From: Simon Davis <Simon.Davis@arun.gov.uk>
Sent: 17 February 2020 15:42
To: Planning.Responses <Planning.Responses@arun.gov.uk>
Subject: FW: re; Pagham breaching the Spit planning application P/12/20/DOC

Natural England's advice on the information submitted to discharge the following conditions:

Part 5 of The Town & Country Planning (Development Management Procedure) Order 2015. Approval of details reserved by conditions imposed under P/97/15/PL relating to

5 Final plans & details concerning design & construction of Tern Island compensation measure;

Fig 5 – Profile and elevation of finished little tern compensatory nesting habitat (metres ODN) on the 'concrete revetment' spit, Pagham Harbour

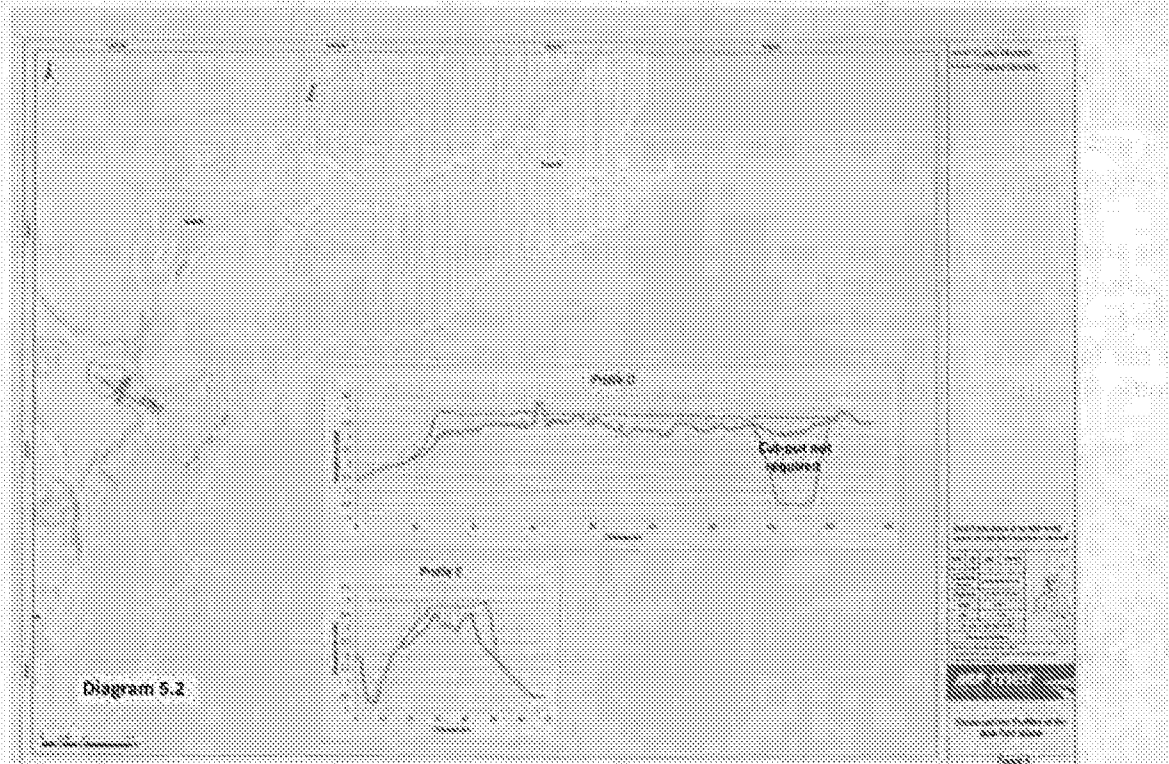
- 14) Following the lessons learnt, by RSPB, in establishing 'artificial' habitat for terns success is not guaranteed in using the compensation habitat little terns. Recent examples have shown that tern chicks have been predated by rats, foxes and gulls, where the concentration of birds/chicks attracts predators. In addition, larger busy colonies deter little terns, who last year located themselves away from the current tern island in Pagham to a naturally accreted shingle strip that RSPB then fenced. The compensation habitat is specifically for little terns, and Natural England has concerns that the habitat may not deliver for this species, due to the similar design to the existing tern island. Therefore, we would advise that the habitat is designed, as much as is possible to attract the little terns and deter other bird species and that remedial action may be required if this habitat is not successful in supporting little terns. This could include potentially shaping the island with a shingle ridge just above high water and then over profiling or shaping the top with a steeper drop away to the west to deter gulls and larger terns nesting on the top.

Fig 9 – Location of little tern compensatory habitat works footprint and main access routes – Pagham Harbour

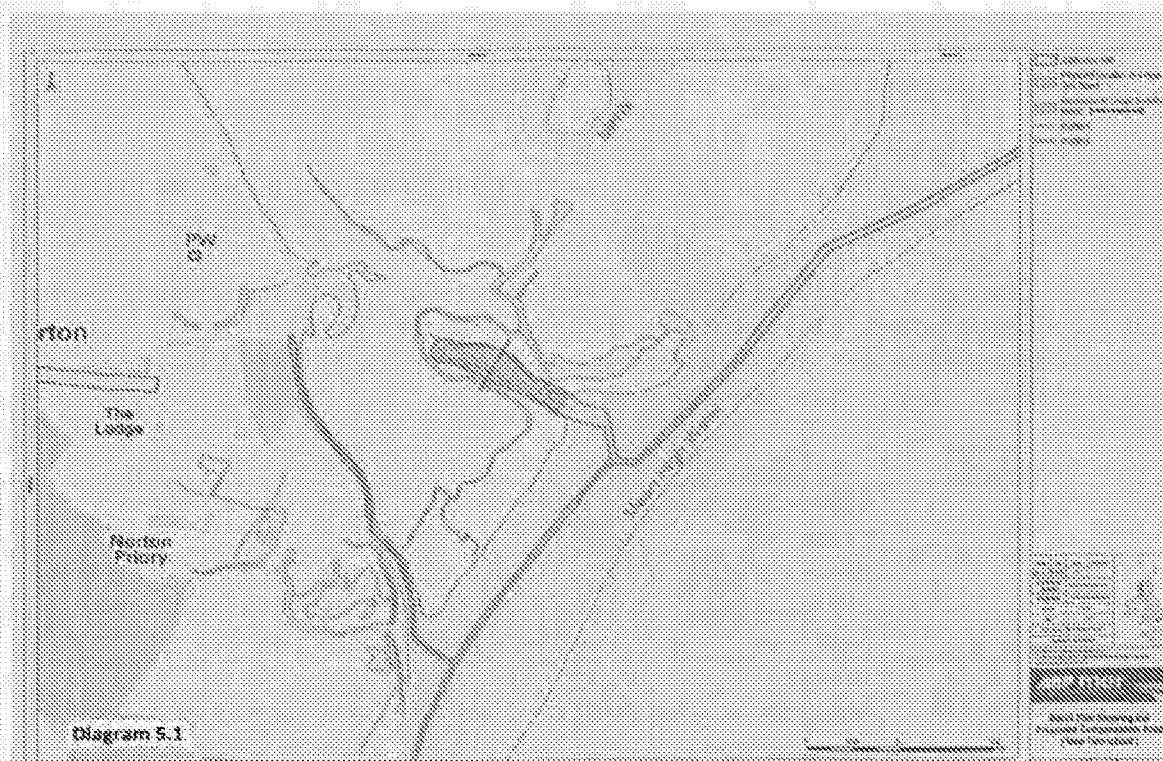
- 7) Two potential routes for vehicles are identified; these are comprised of either existing tracks or within the intertidal area. Care must be taken where vehicles pass or turn to ensure no damage to the vegetated shingle or geomorphology.

- 8) Both routes have areas where vegetated shingle will be crossed, at these locations matting must be used.
- 9) The area between the Church Norton spit and the rock revetment, where the little tern compensation habitat is to be constructed, contains particularly sensitive shingle heath habitat of lichens and mosses. Access on the eastern side of the revetment is less sensitive and should be the route used to access the revetment; matting also needs to be used at this location to minimise damage to this sensitive habitat.
